RE: MS212; Bradley Point Filing No.1 Amendment

RE: Project File Number: MS212
Project Name: Bradley Point Filing No. 1
Parcel Number: 6503403002 & 6503403003
Commissioner District: 4

RE: Bradley Point Filing No. 1
Project EA No. EA20100 / File No. MS212

MS-21-2 Bradley Point Filing No. 1

FINAL PLAT  
BRADLEY POINT FILING NO. 1  
JOB NO. 70-074  
DATE PREPARED: 01/29/2021  
DATE REVISED: 08/22/2023

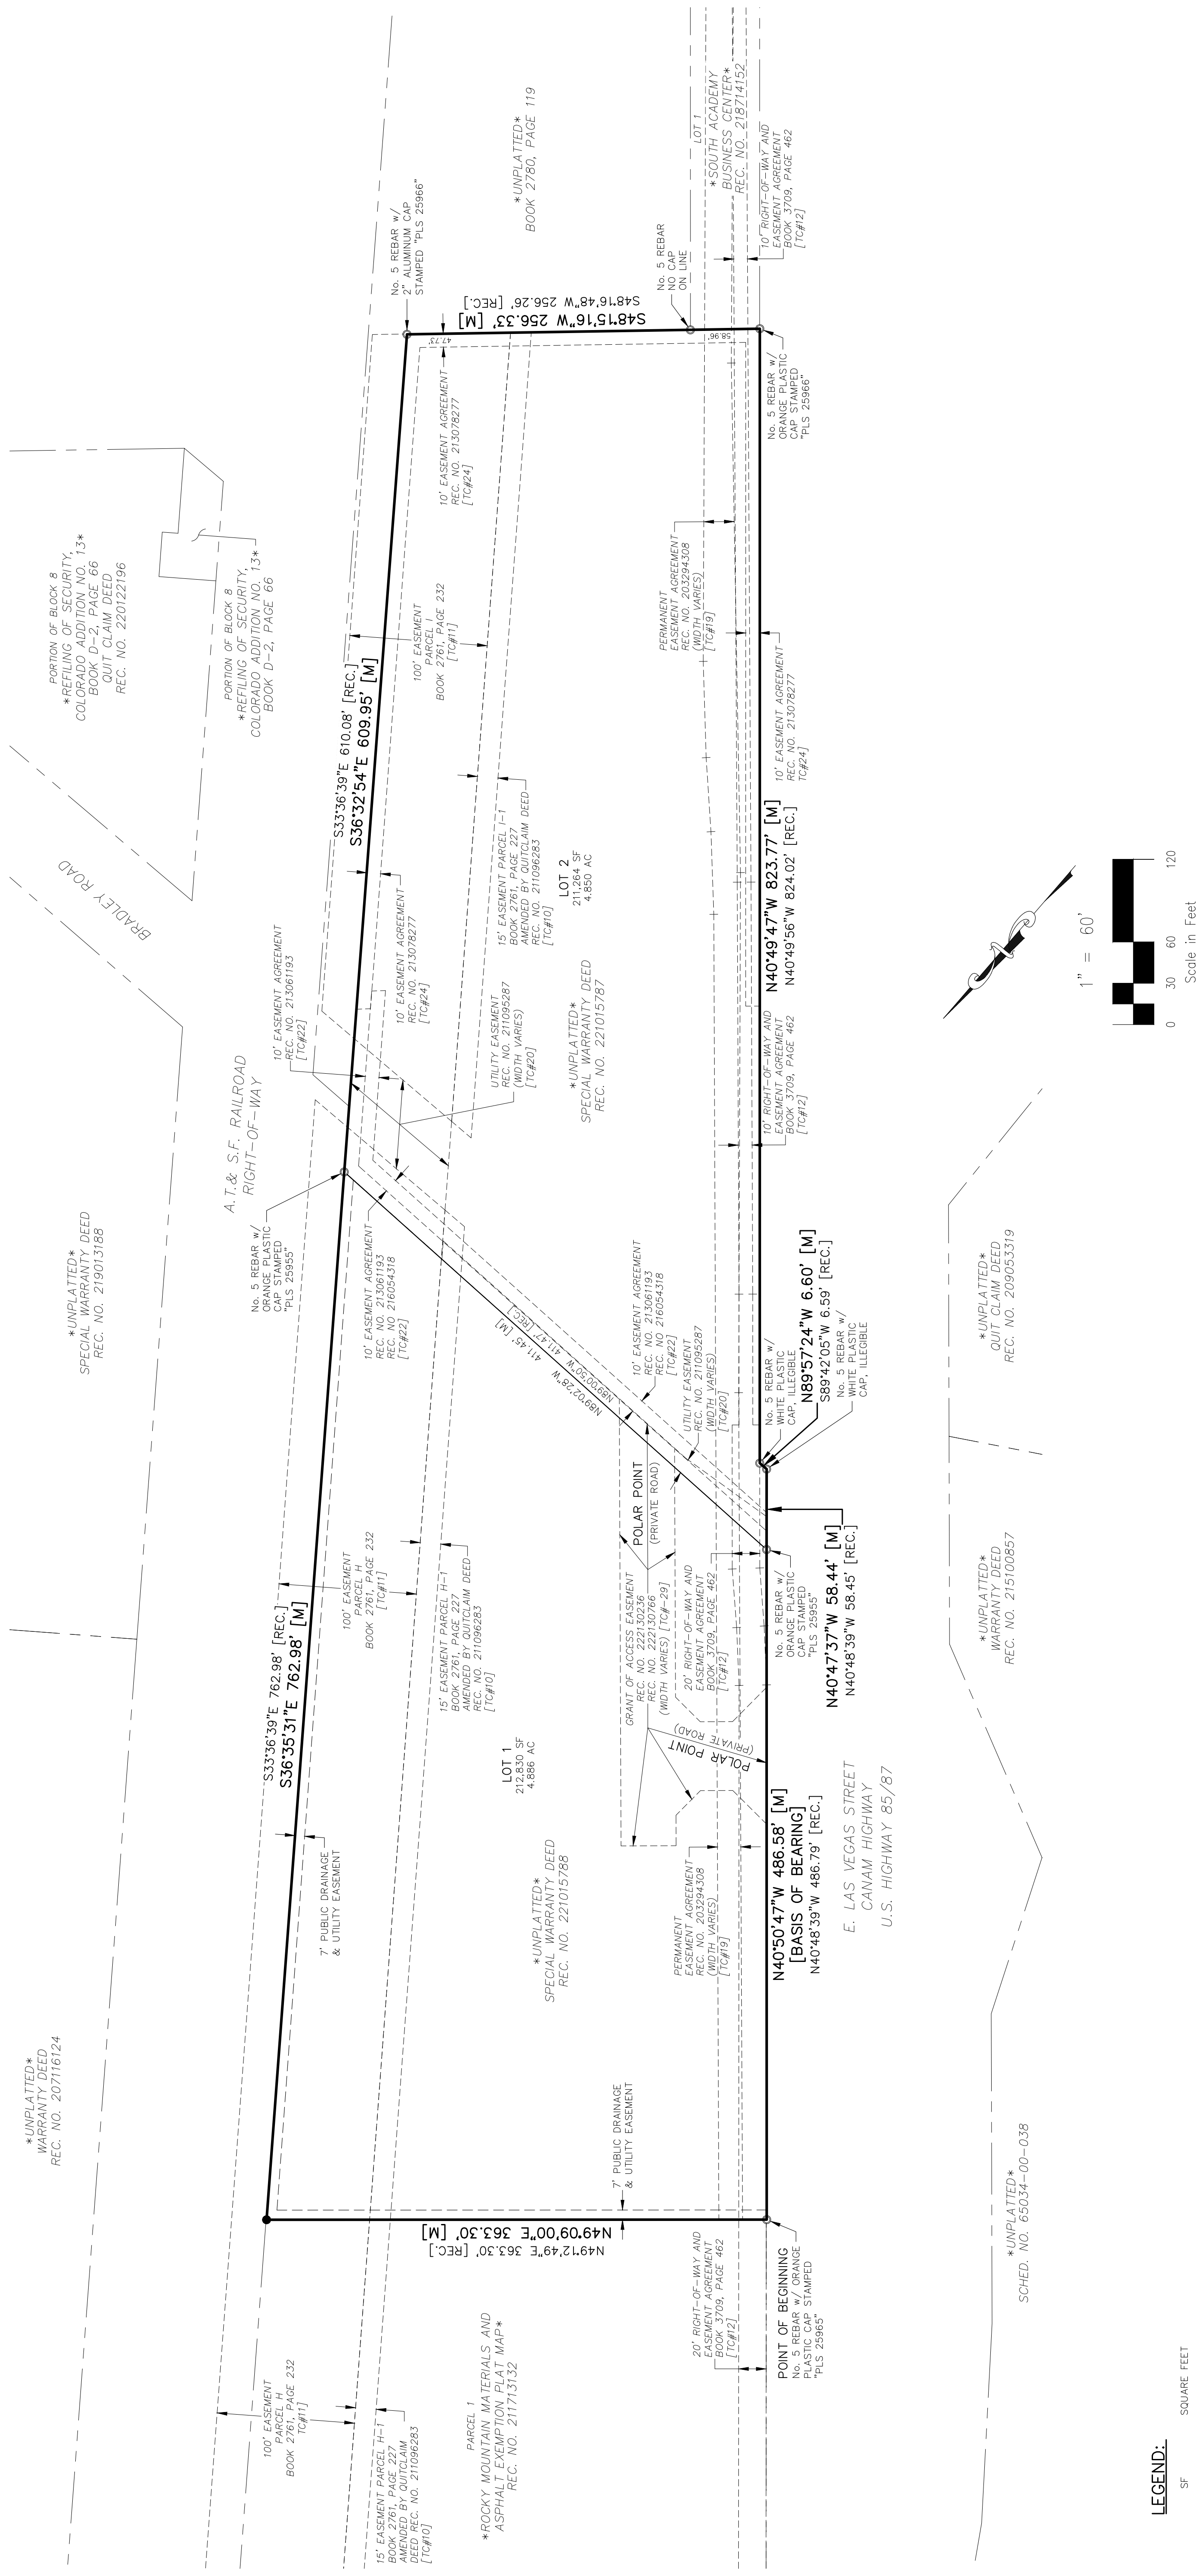
- A. Applicant and all future owners of lots within this filing shall be advised of, and comply with, the conditions, rules, regulations, limitations, and specifications set by the District.
- B. **Prior to recording the final plat:**
 - 1. Delete Note 10 from the face of the plat.
 - 2. Provide for review by the County Attorney's Office an updated letter of intent that removes all references to this being a dry subdivision and that addresses the water sufficiency criteria for final plats, as a typical letter of intent would.
